**Ref:** SSD-82548708  
30 June 2025

**RE: SUBMISSION TO SSD-82548708, RESIDENTIAL FLAT BUILDING WITH INFILL - AFFORDABLE HOUSING - 24,26 &28 Middle Harbour Road**

**Ku-ring-gai Council's objection/submission to SSD-82548708 for Residential Flat Building with Infill - Affordable Housing at No. 24,26 & 28 Middle Harbour Road**

Drawing Name
Level 04 Setback

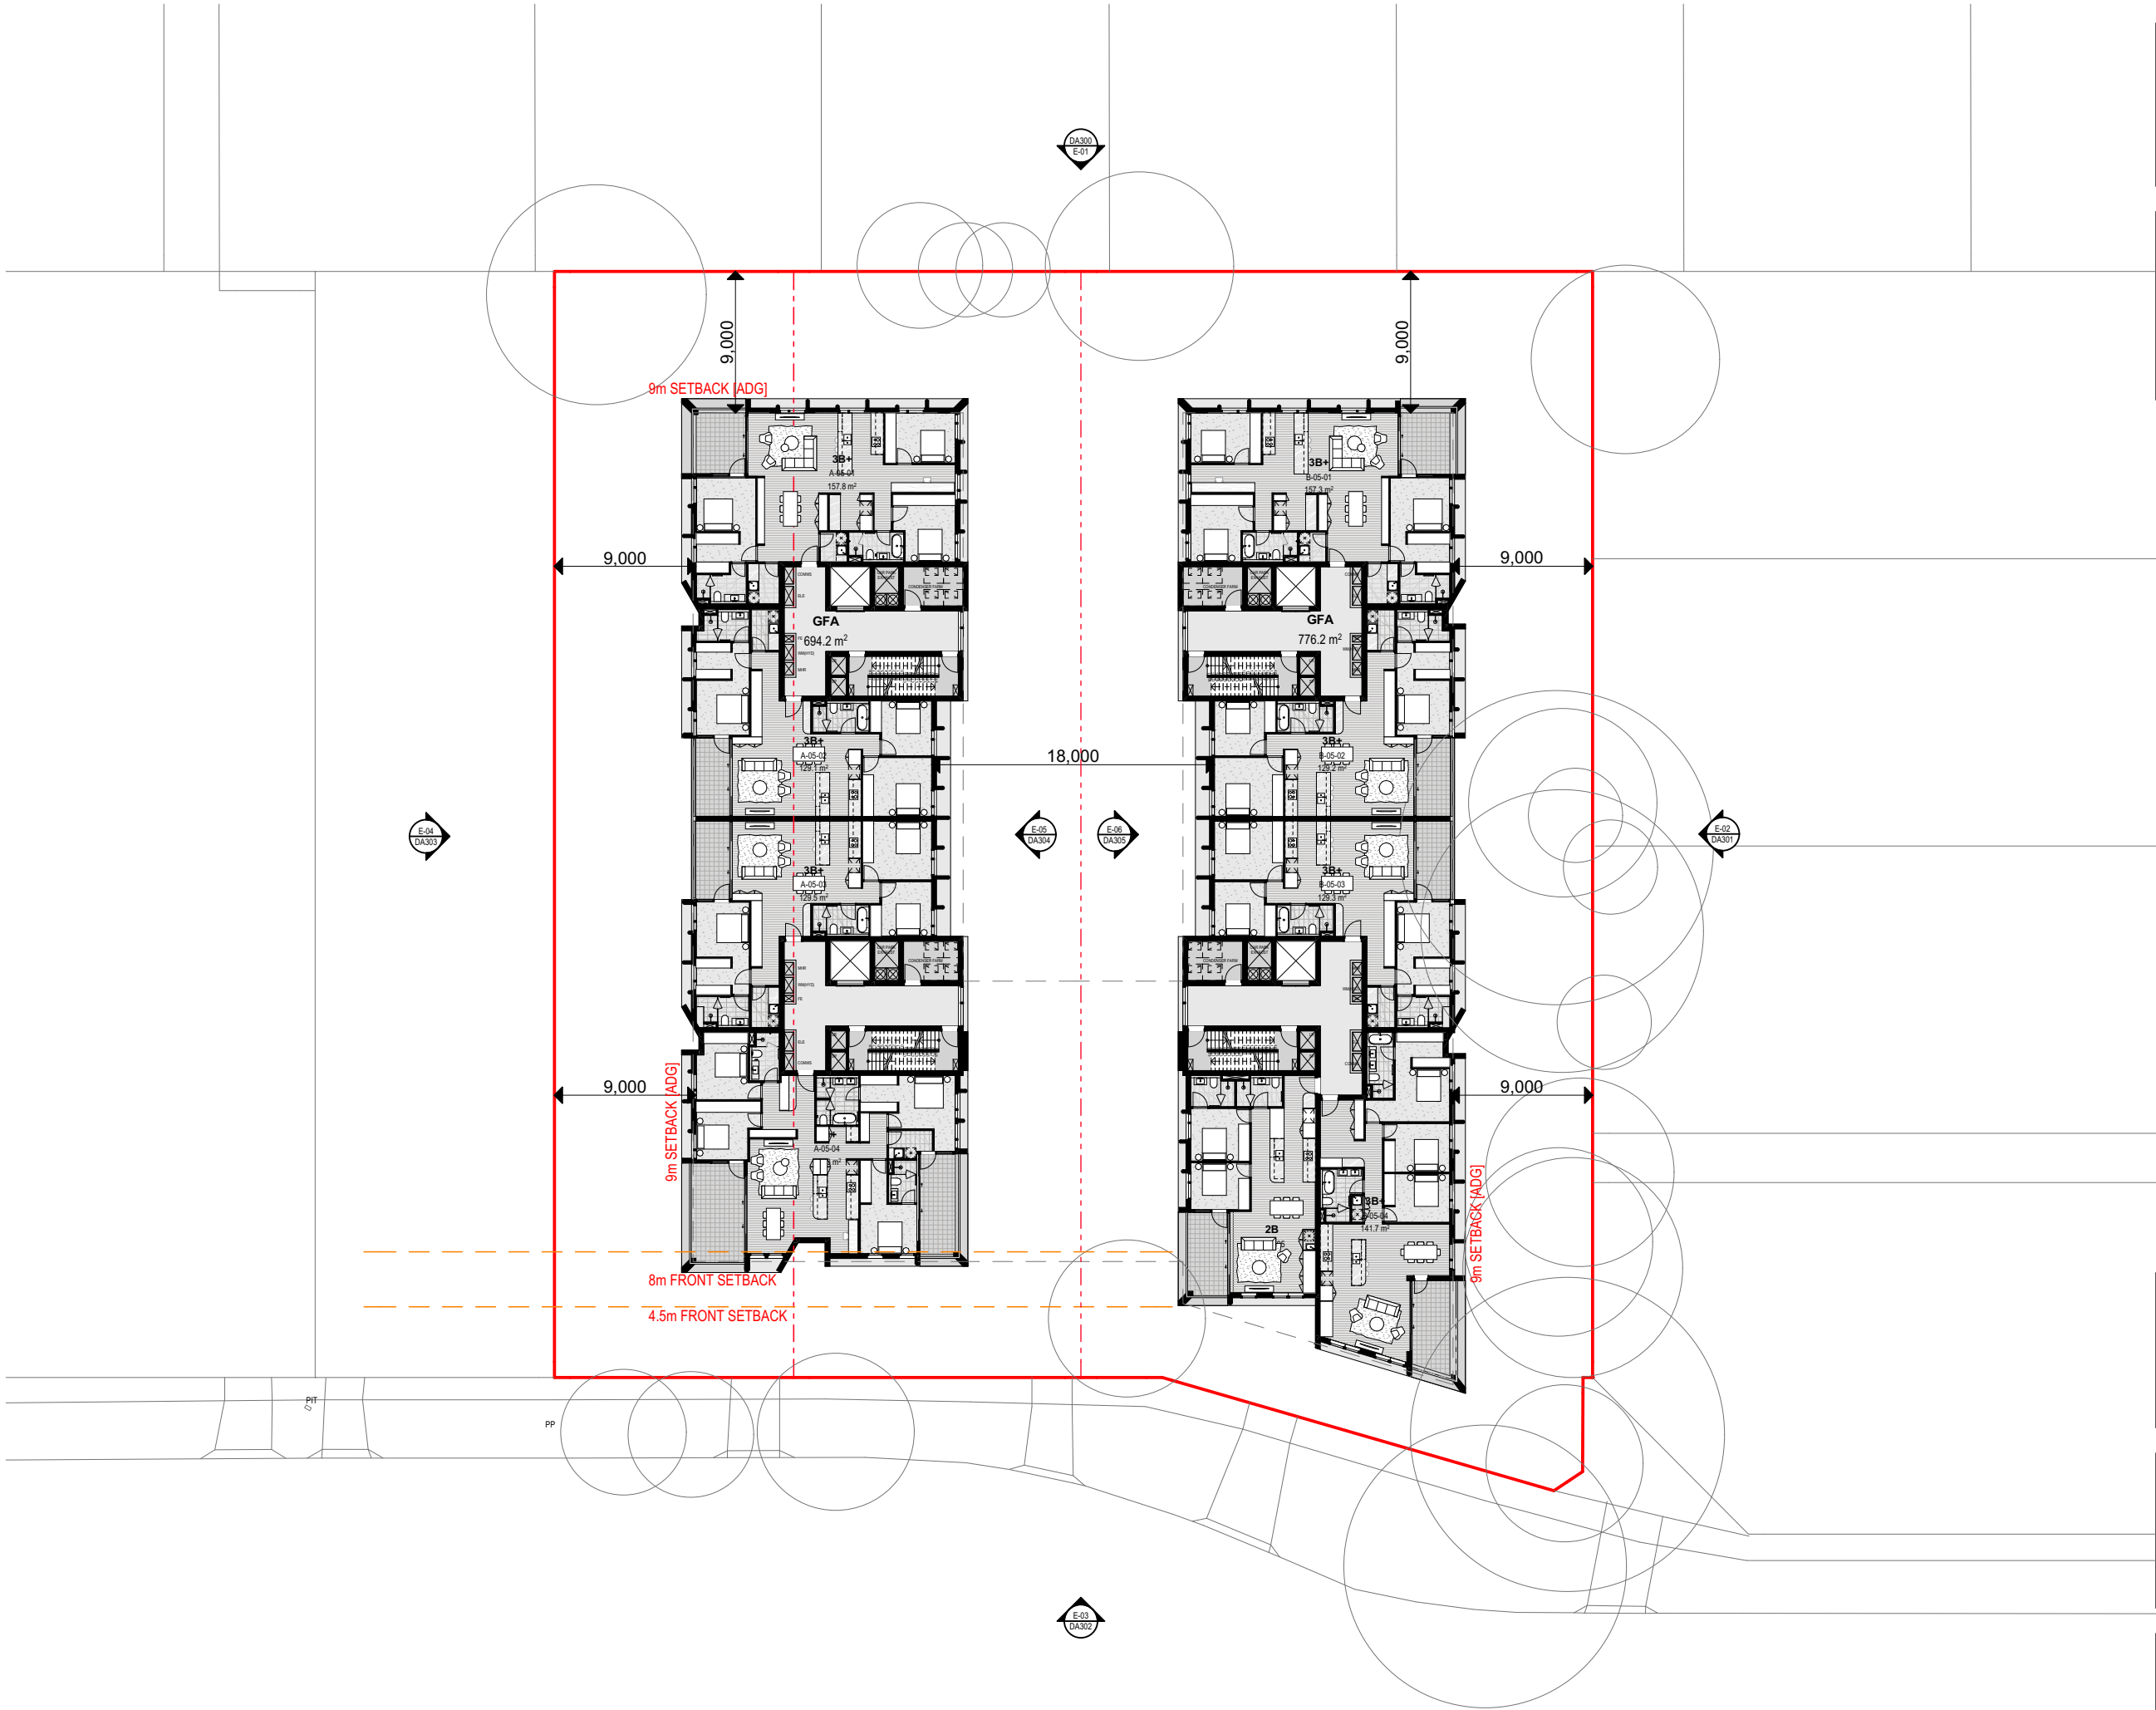
- The top storey of the building has not been set back the minimum 2.4 metres from the outer face of the floors below as required in Part 7C.8, and is instead aligned with the storey beneath it. This results in excessive visual bulk and a lack of modulation at the upper level. The design should be amended to provide additional setbacks at the top storey to reduce the perceived massing and ensure a more articulated and recessive upper form.
- The side and rear façades of the proposed buildings have not been adequately articulated to reduce the perceived building mass. As a result, the development presents significant bulk and scale impacts when viewed from adjoining and rear properties.

Drawing Name
Deep Soil Diagrams

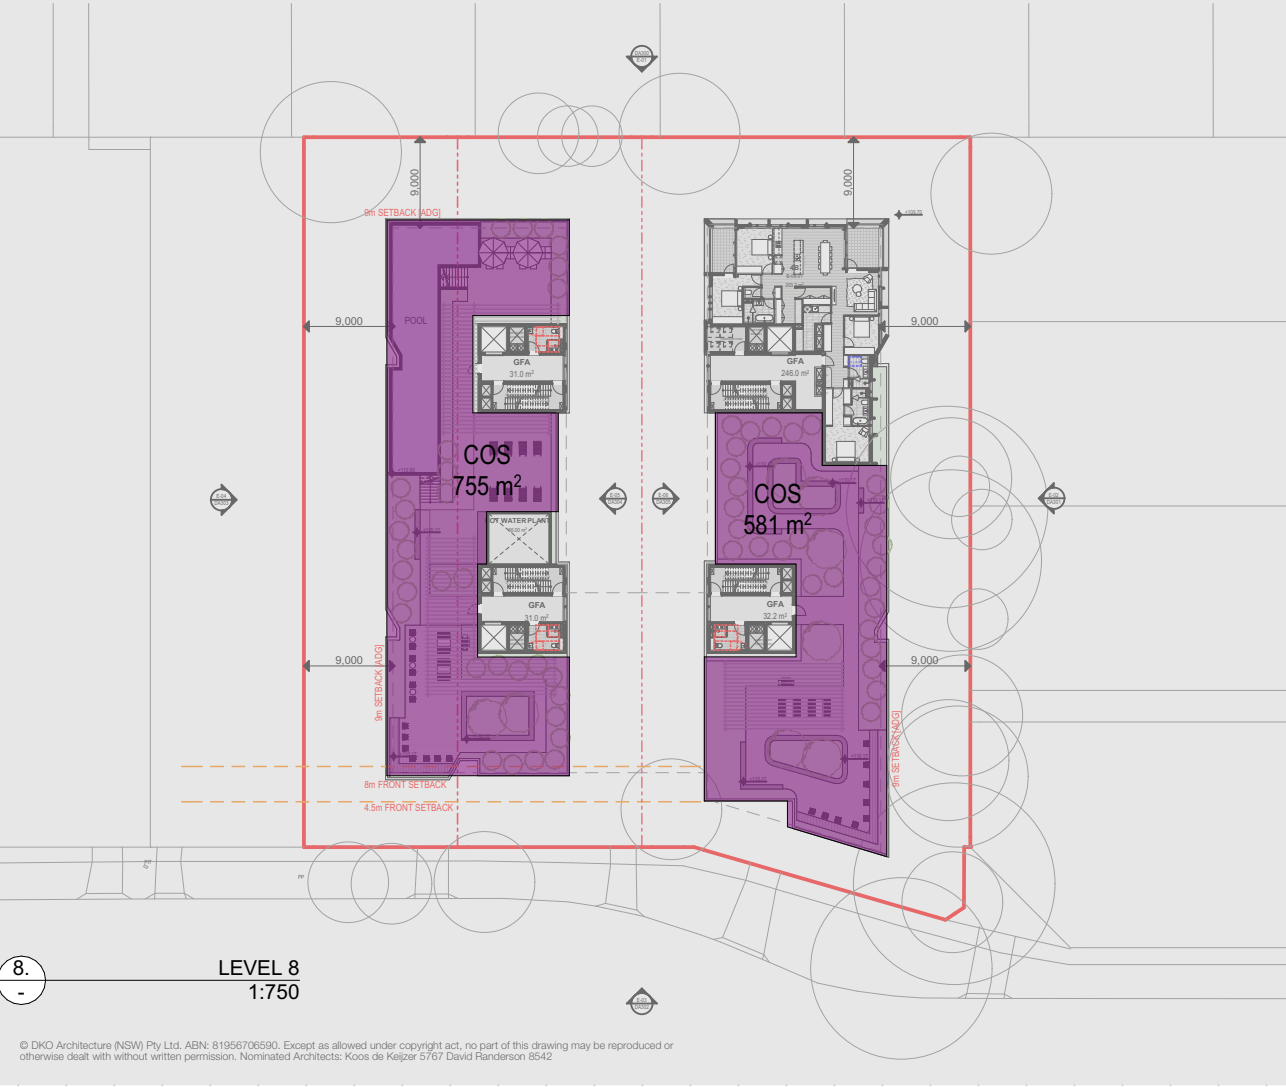
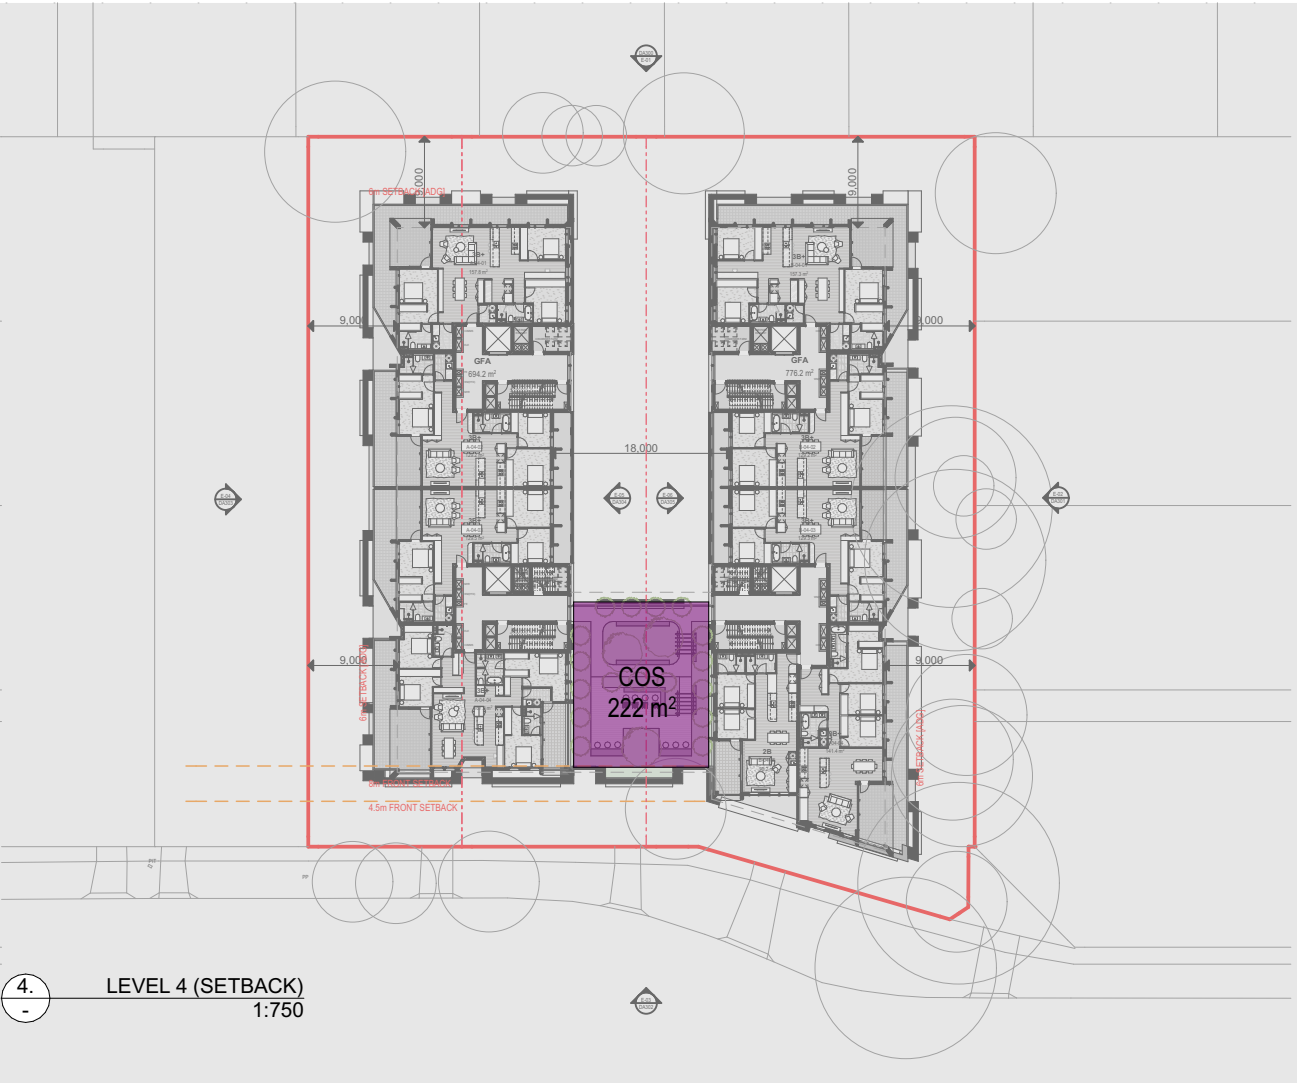
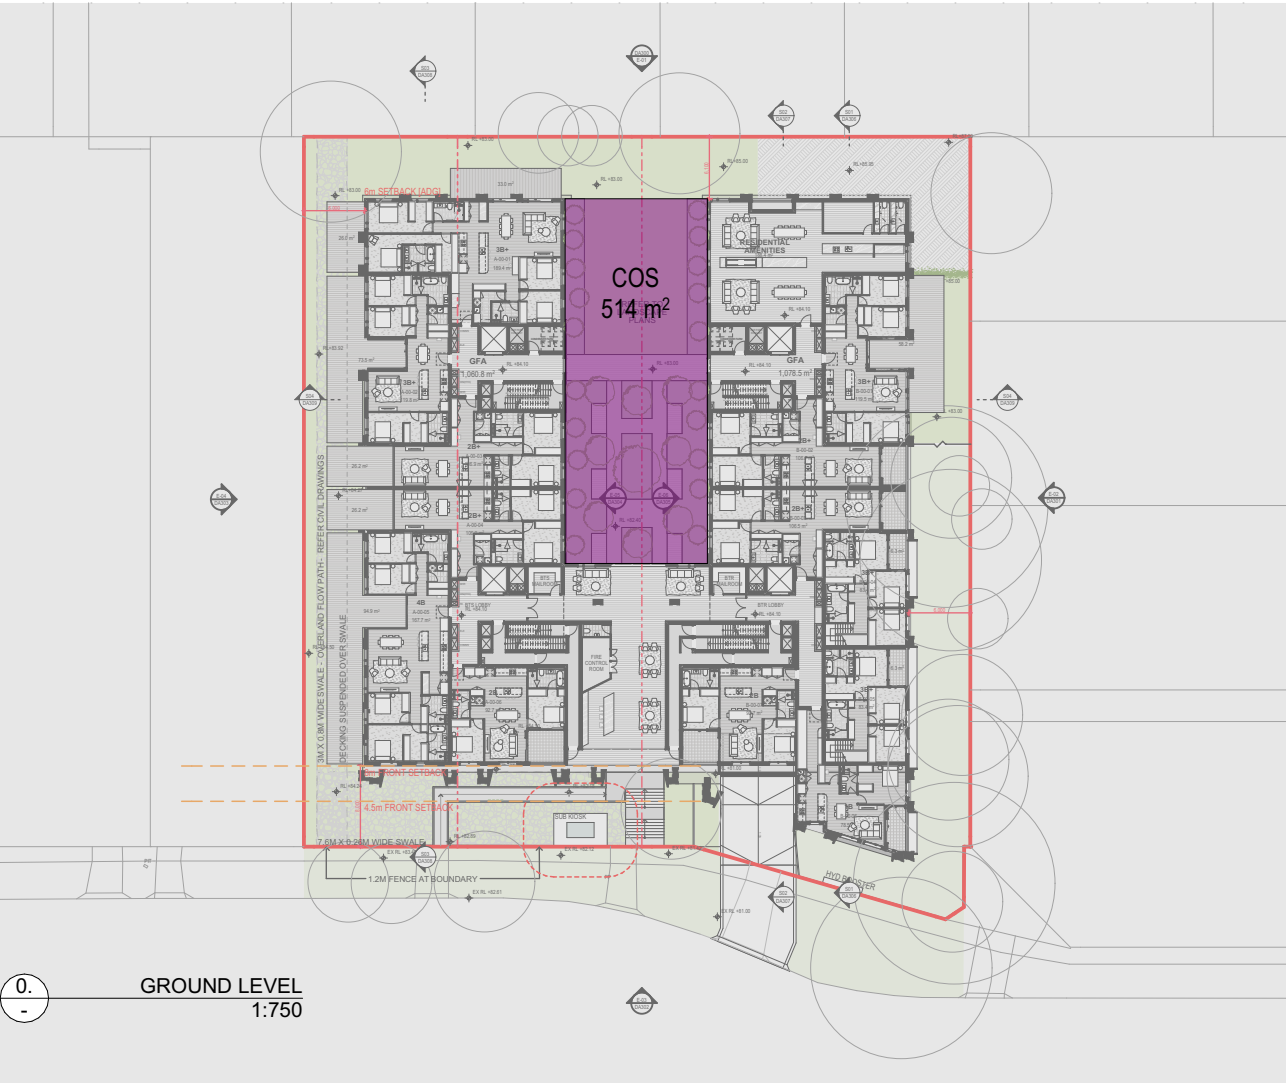
The application states that 1,350m<sup>2</sup> of deep soil is proposed, equating to 28.37% of the site area. However, this figure appears to be overstated and does not accurately reflect compliance with the ADG definition of deep soil, due to the following concerns:

- Northern boundary: The full setback is counted as deep soil, despite the basement encroaching to within 5.5 metres of the boundary—below the required 6-metre minimum dimension. The presence of elevated decking in this zone further disqualifies portions from being classified as deep soil. Only the central section of this area (approximately 10.9 metres wide) may be considered as deep soil.

- Eastern and western boundaries: The proposal counts the full width of these setbacks, despite the basement being located only 4.6 metres from the boundary. In addition, ground-level decking extends into these zones. Under the ADG definition, these areas do not qualify as deep soil.

- Southern boundary: Although much of this area is counted as deep soil, the basement to the east of the driveway is only 4.9m from the boundary. To the west, while the basement maintains a 6-metre setback, the presence of built elements such as stairs, pathways, and a sub-kiosk disqualifies large portions of this zone from being considered true deep soil.

Given the above, there are significant concerns that the proposal does not achieve the minimum 7% deep soil requirement under the ADG, and falls well short of the recommended 15% for a site of this size. A revised calculation and clarification of the deep soil areas is strongly recommended.
